State Significant Development Application and Variation of the Sydney Cove Redevelopment Scheme for the 'Remediation, Renewal and Adaptive Re-Use of Campbell's Stores', The Rocks (SSD 7056)

My second submission is an objection on **HERITAGE** grounds in relation to:

Drawing Title  
**ELEVATIONS**  
JPW Project Number  
12006  
Drawing Status  
EA  
Drawing Number  
EA-A-2000  
Revision  
B

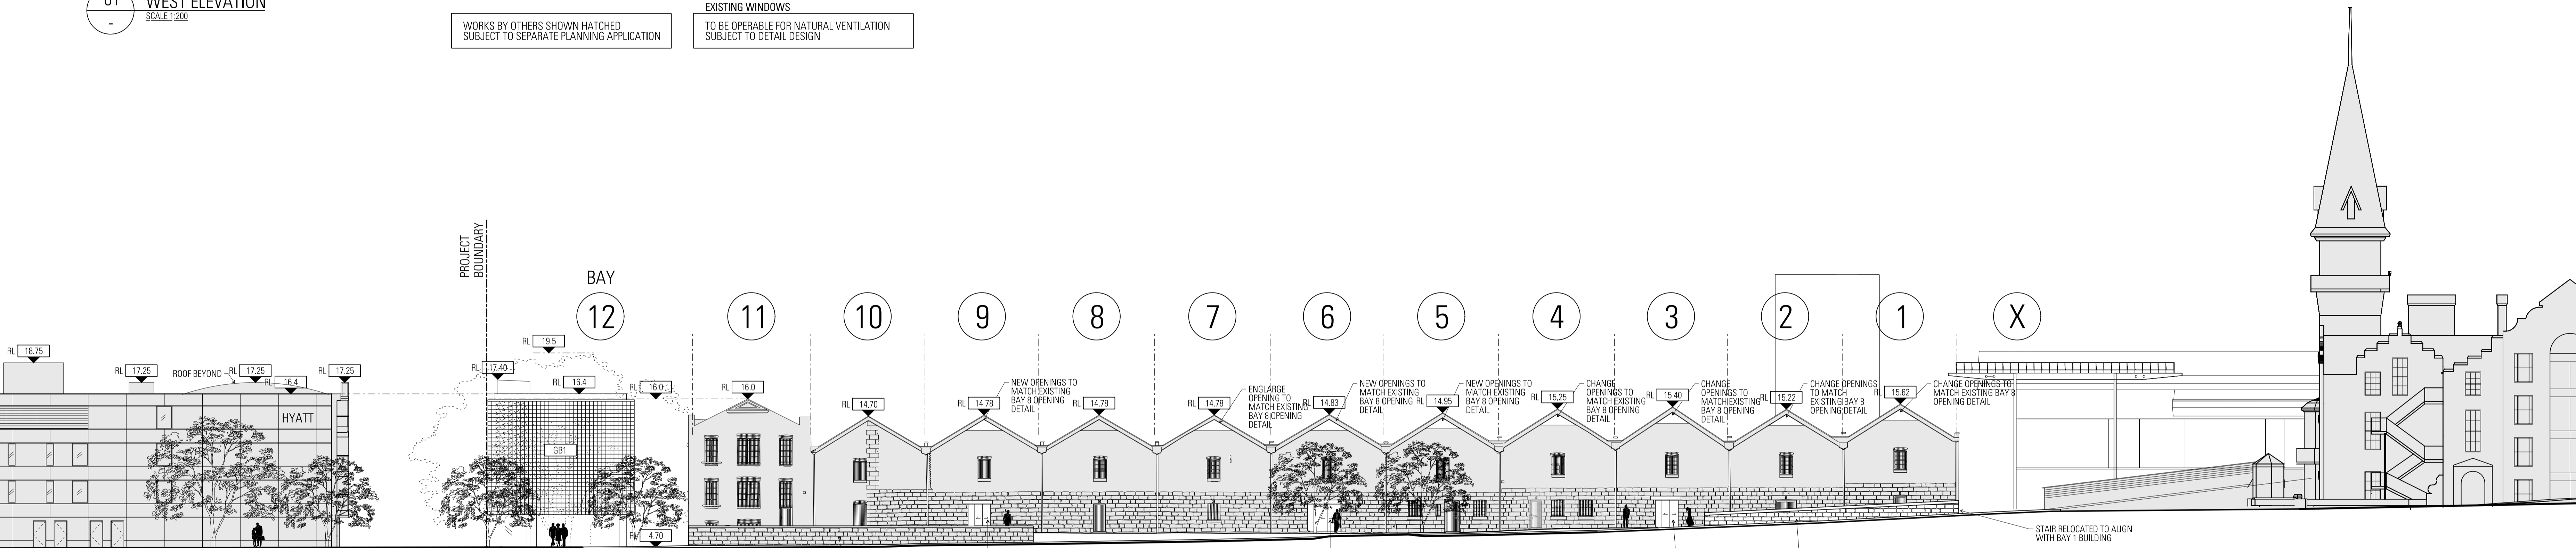
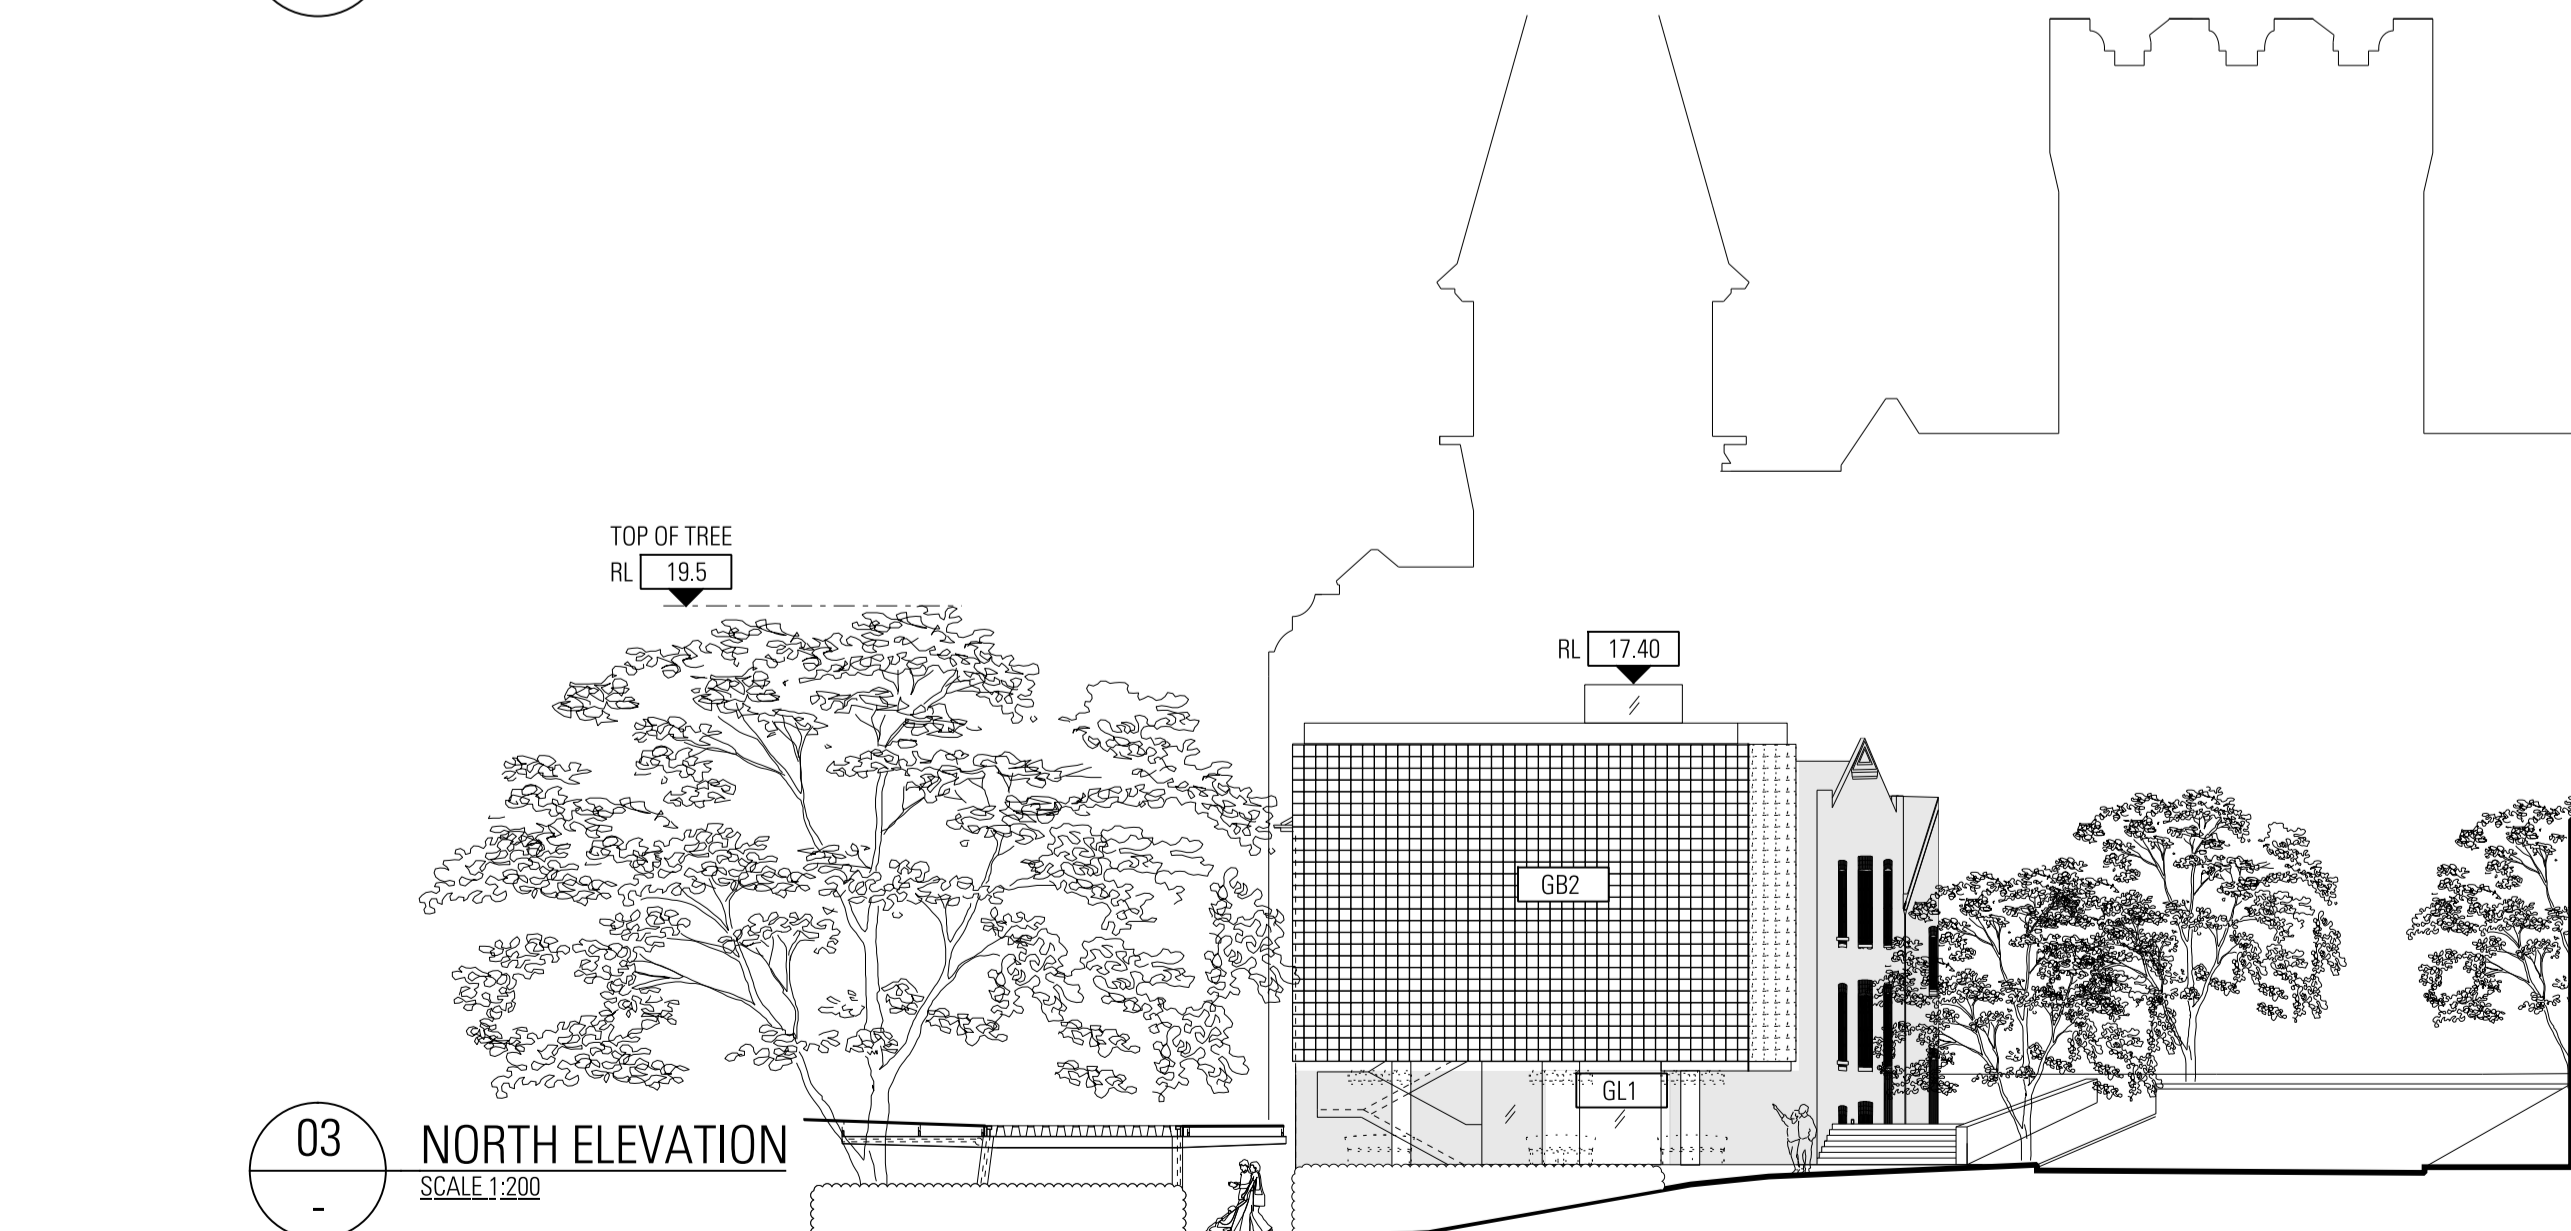
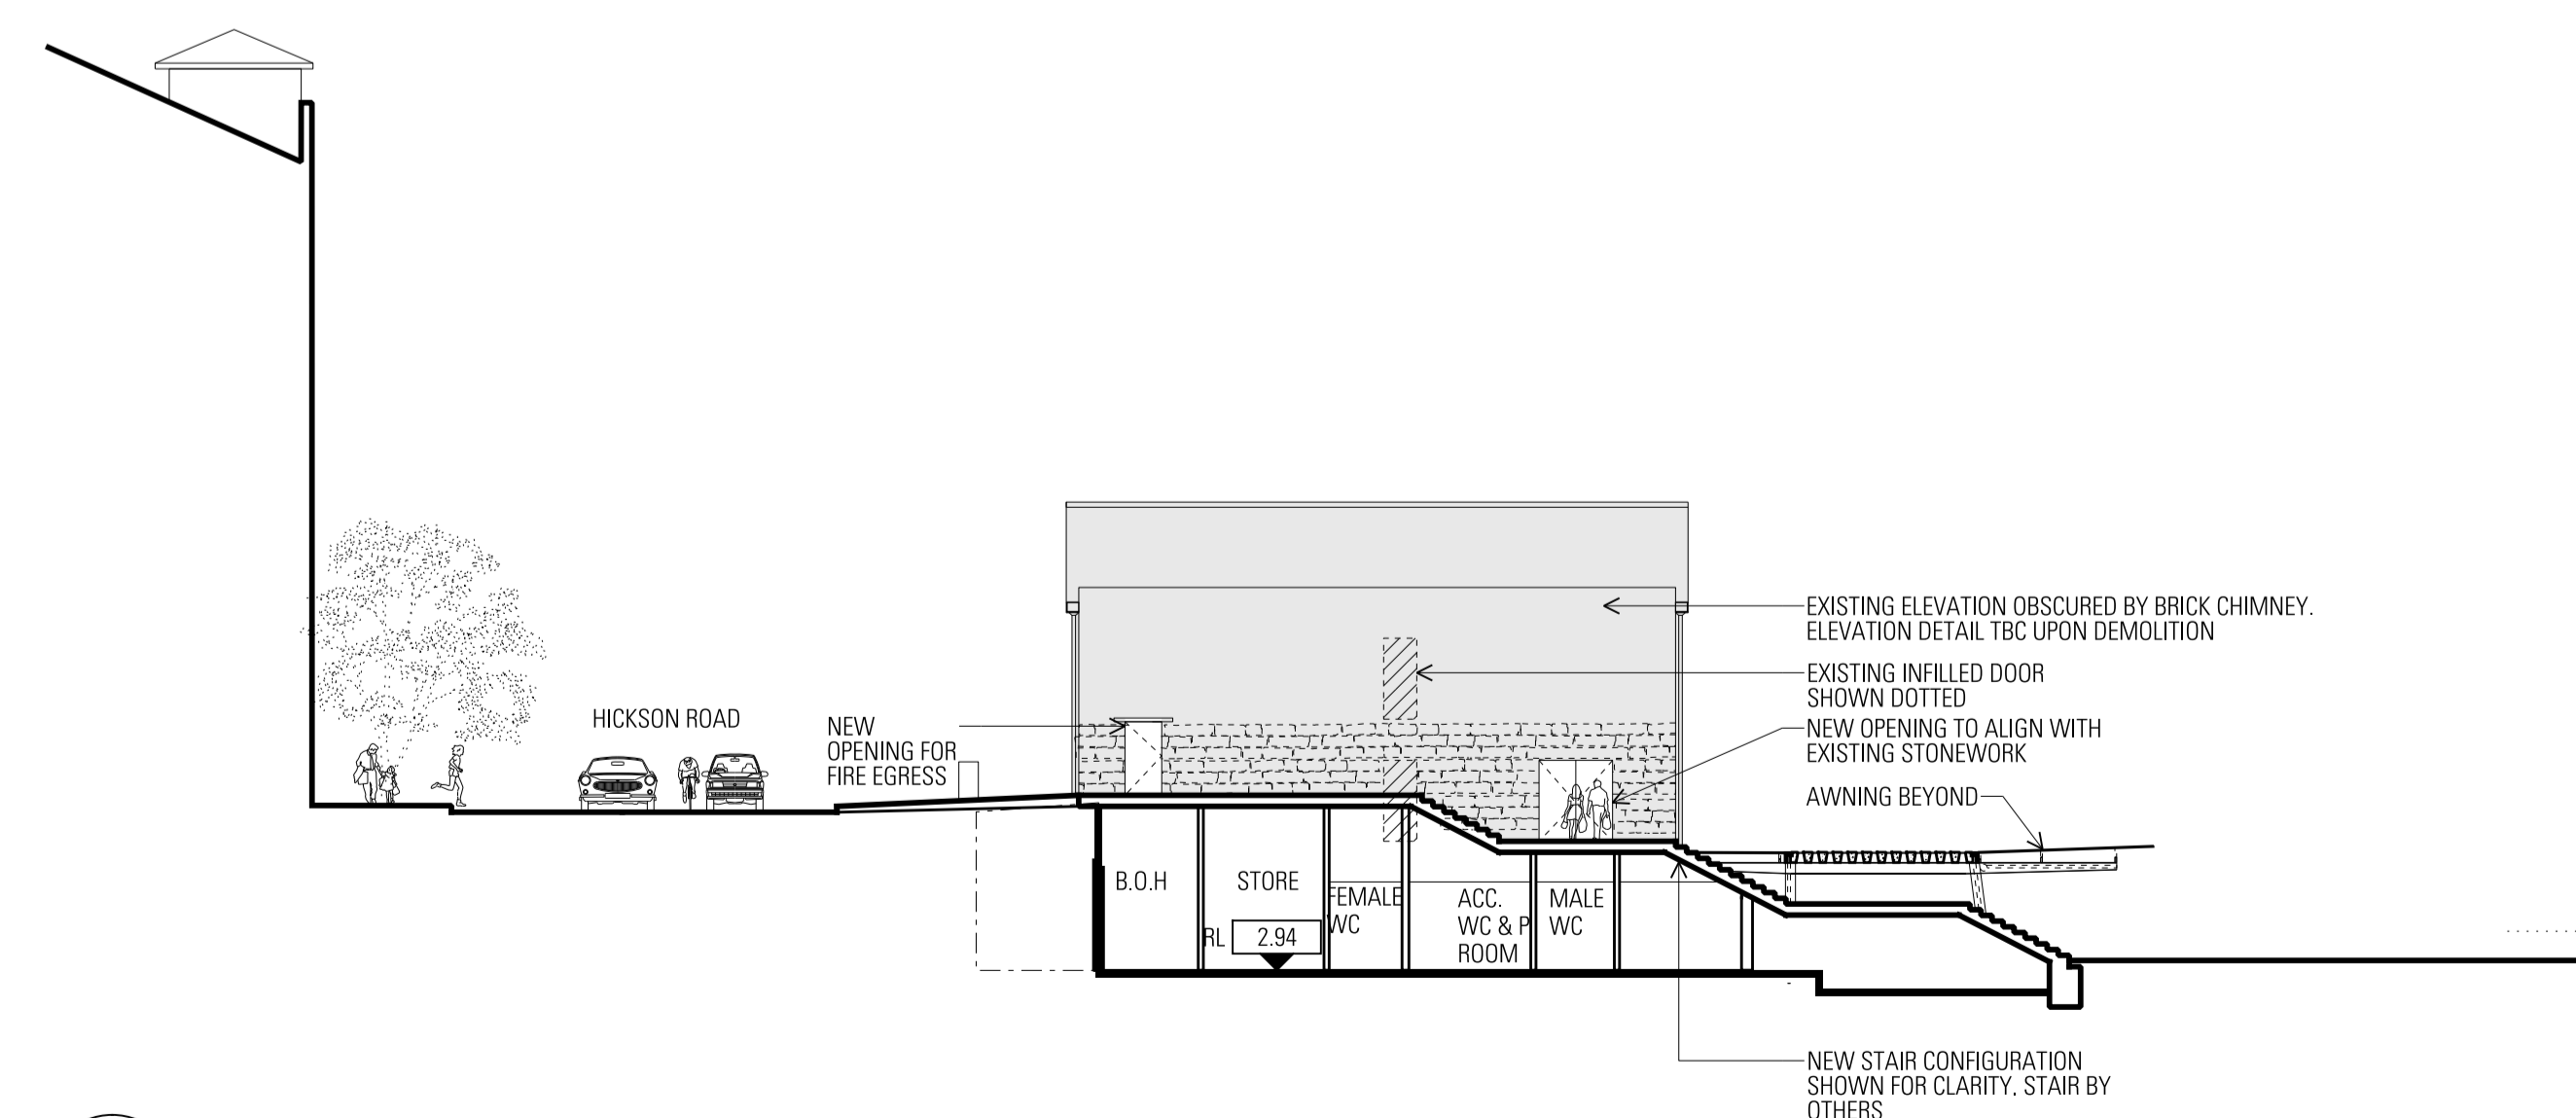
- widening of the existing c.1915 openings on the Hickson Rd frontage to create three new and much larger concrete entry portals. Creating these openings will destroy sections of the building's early sandstone brickwork and the end product will encroach upon the City of Sydney's existing pedestrian footpaths. The openings will all have back-lit signs and the centre opening will cut right through the building further damaging its original fabric.

- the creation of outdoor eating areas, with chairs, tables and umbrellas on Hickson Rd. While this is an appealing image, it would reduce visibility to this (western) side of the Stores and limit people's opportunity to appreciate the building's original form and function. This western elevation is the side that is most in keeping with the original form of Campbell's Stores and the one that most reveals the Stores' 19th century character. To maintain its heritage significance, this façade needs to be kept intact as much as possible.

- the removal of the existing awnings and canopies adjoining the eastern elevation of the Stores. This is the elevation that faces the foreshore and the Opera House so removing these intrusive elements would reveal the building they currently hide. However, this improvement would be short-lived. The applicant wants to replace the old intrusive elements with new ones - stand-alone canopies that feature perforated precast concrete roofs. These are not transparent and so will prevent the public having clear views of the eastern (foreshore) side of Campbell's Stores.

- appreciate this heritage building,
- the creation of two new openings in the south elevation and the closure of one of the heritage openings. This will be a missed opportunity to reveal this elevation in its original form and a further blow to the building's heritage significance.
- the contravention of a large number of policies within the Campbell's Stores Conservation Management Plan (CMP), which SHFA commissioned and which the Heritage Council endorsed in July 2014, only 18 months ago. These include:

- The glass building would comprise three levels sitting on four columns. It would have the appearance of a tall and bulky glass box on stilts and would obscure all of the Stores' northern elevation. Its minimal 2.5 metre undercroft would be oppressive and tunnel-like and this, along with its intended use for outdoor eating, would serve as a barrier, limiting public access to the foreshore and severely constraining existing views to the Opera House from this location.

- The proposed glass box would be located next to Bay 11 on the northern elevation of Campbell's Stores. When measured from the proposed new ground level, it would be 13.3 metres high with the inclusion of its 1 metre high lift overrun. This exceeds the height restriction on the foreshore frontage by 14.5m, more than 250% and on the Hickson Road elevation by 10.5m, or 140%. This would require a significant spot re-zoning under the

- The proposed new ground level would be 1.94 metres higher than the existing one so as to accommodate a basement area. Contrary to claims that there would be a four metre setback between the two buildings, the basement level of the glass box would abut the Stores and effectively bury the ground floor of the Stores' 'Highly Significant' northern façade almost to the tops of its existing windows. This is shown very clearly in the following sections of JPW's Design Statement – the northern elevation profile (p.96,) the Concepts diagram (p.102) and the Bay 12 'adistic imdression' (artistic impression?) listed for the 4th of the series of 'Day 12' (Bay 12?) images. (no page number given). The 5th 'Day 12' image on the following page omits showing the upper section of the windows. It therefore misleads the reader as to the significant extent to which the raised ground level 'buries' the northern elevation of Campbell's Stores.
